RE SSD – 8924 – The new Sydney Fish Market Concept and Stage 1
SSD – 8925 – The new Sydney Fish Market Stage 2

LETTER OF OBJECTION

### Diagram : Promenade Stairs

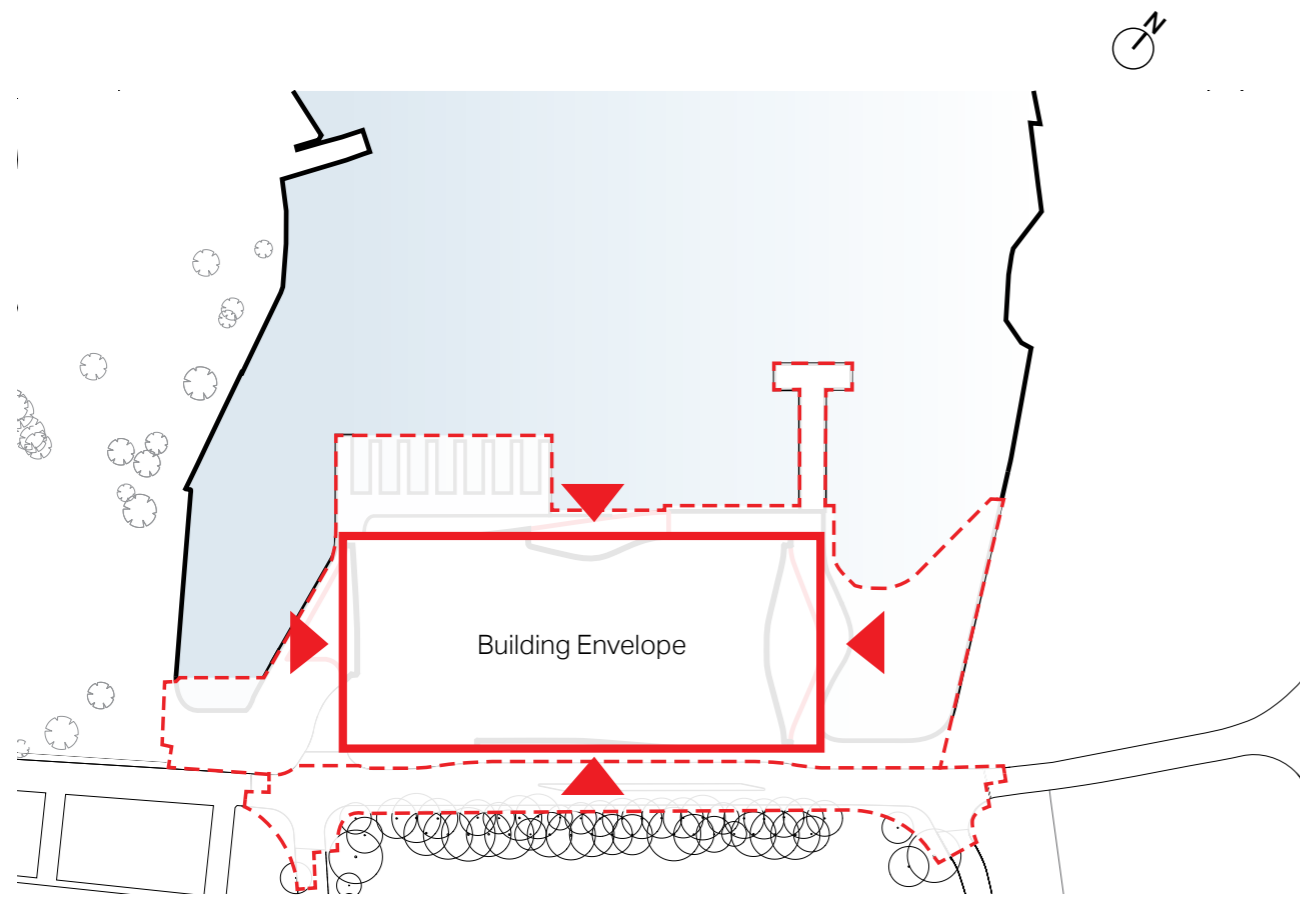
DISCRIMINATION AGAINST PEOPLE WITH MOBILITY IMPAIRMENT – The DA papers acknowledge that the Glebe Foreshore walk is amongst the best in the world. The proposed extension of the walk at the Fish Markets forces walkers to climb stairs, and those in wheelchairs to find a lift inside the building – a contravention of the Disability Discrimination Act 1992's requirement that people with disabilities have 'equitable', 'independent', and 'dignified' access "on the same terms" as people without disability. This is shameful discrimination by the State Government and its agencies.
